**Consultation Response from KC,
Lead Local Flood Authority**

2025/93225 The Richardson Arms, 684, Bradford Road, Oakenshaw, BD12 7EN

**Alterations to convert former public house to 5 flats and erection of 4 dwellings with
associated works**

Date Responded: 10th April 2025

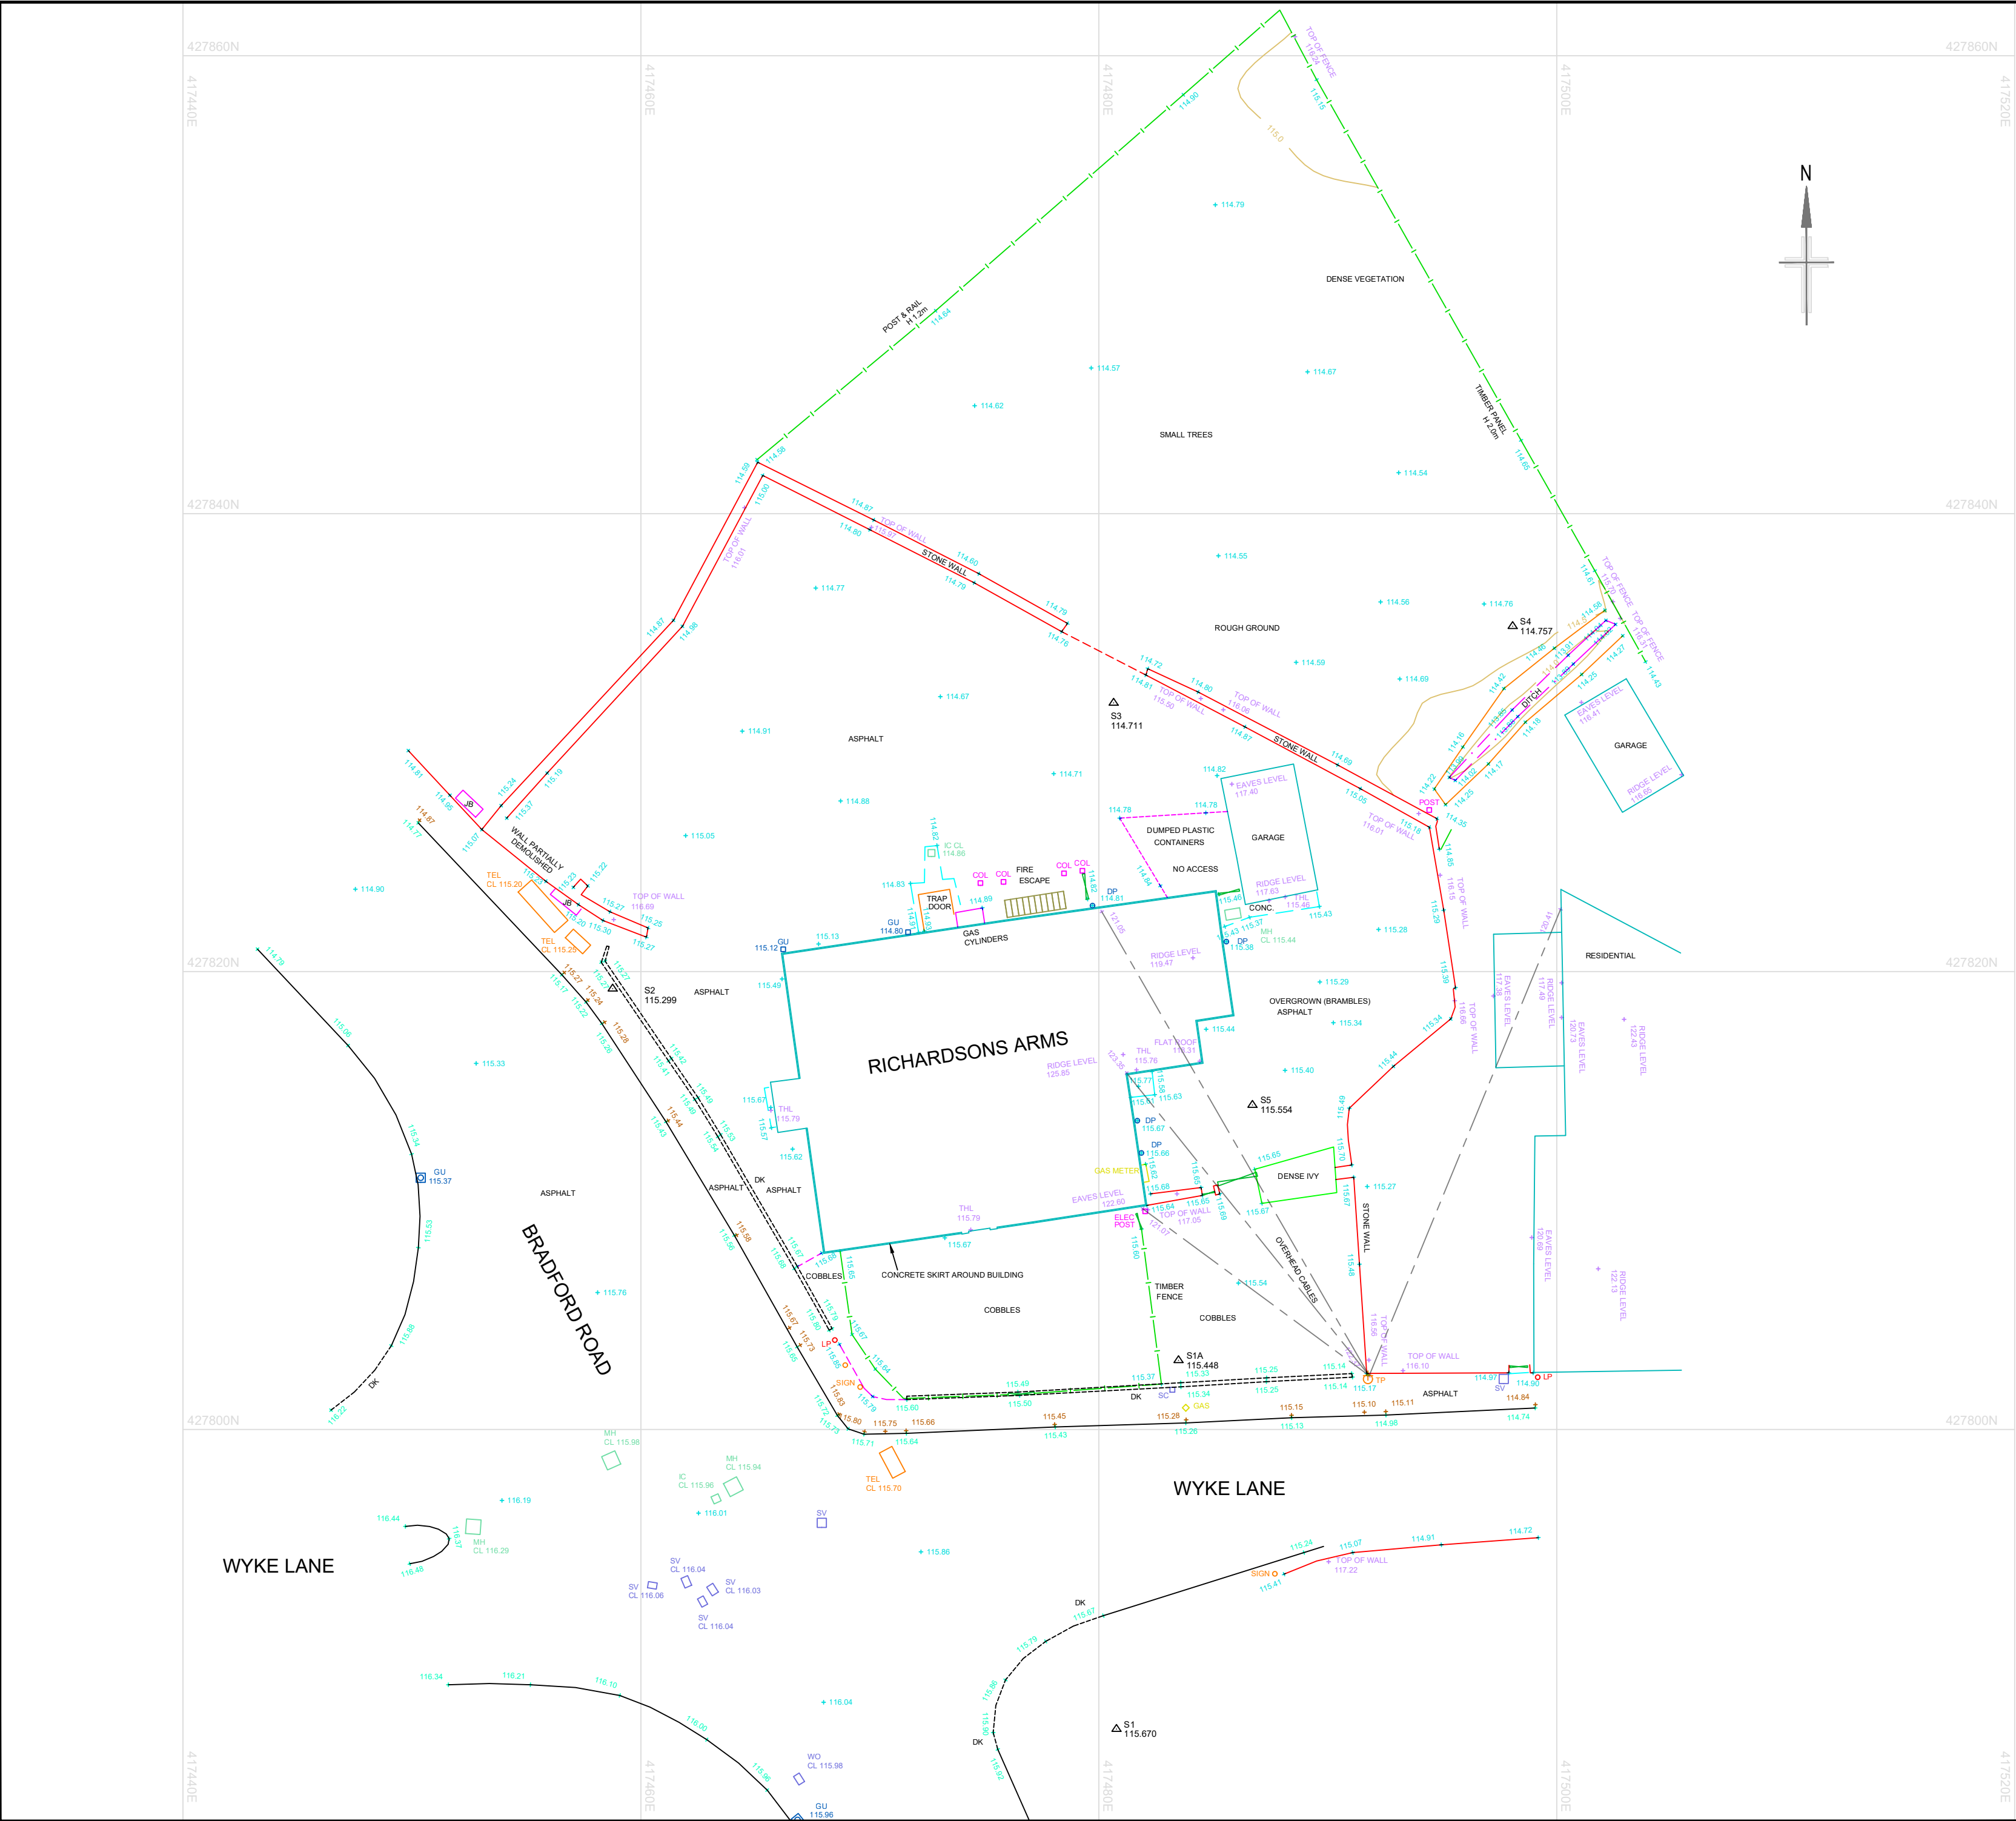
- Statutory records show public sewers crossing the site in two places. Verification of the location of these sewers is required. This is in addition to any existing drainage plans for the Richardson's arms as these sewers are shown to serve adjacent properties, 5 and 7 Wood View. Also, a sewer showing in the red line boundary requires downstream survey to show how it connects to other systems in the vicinity of the site.
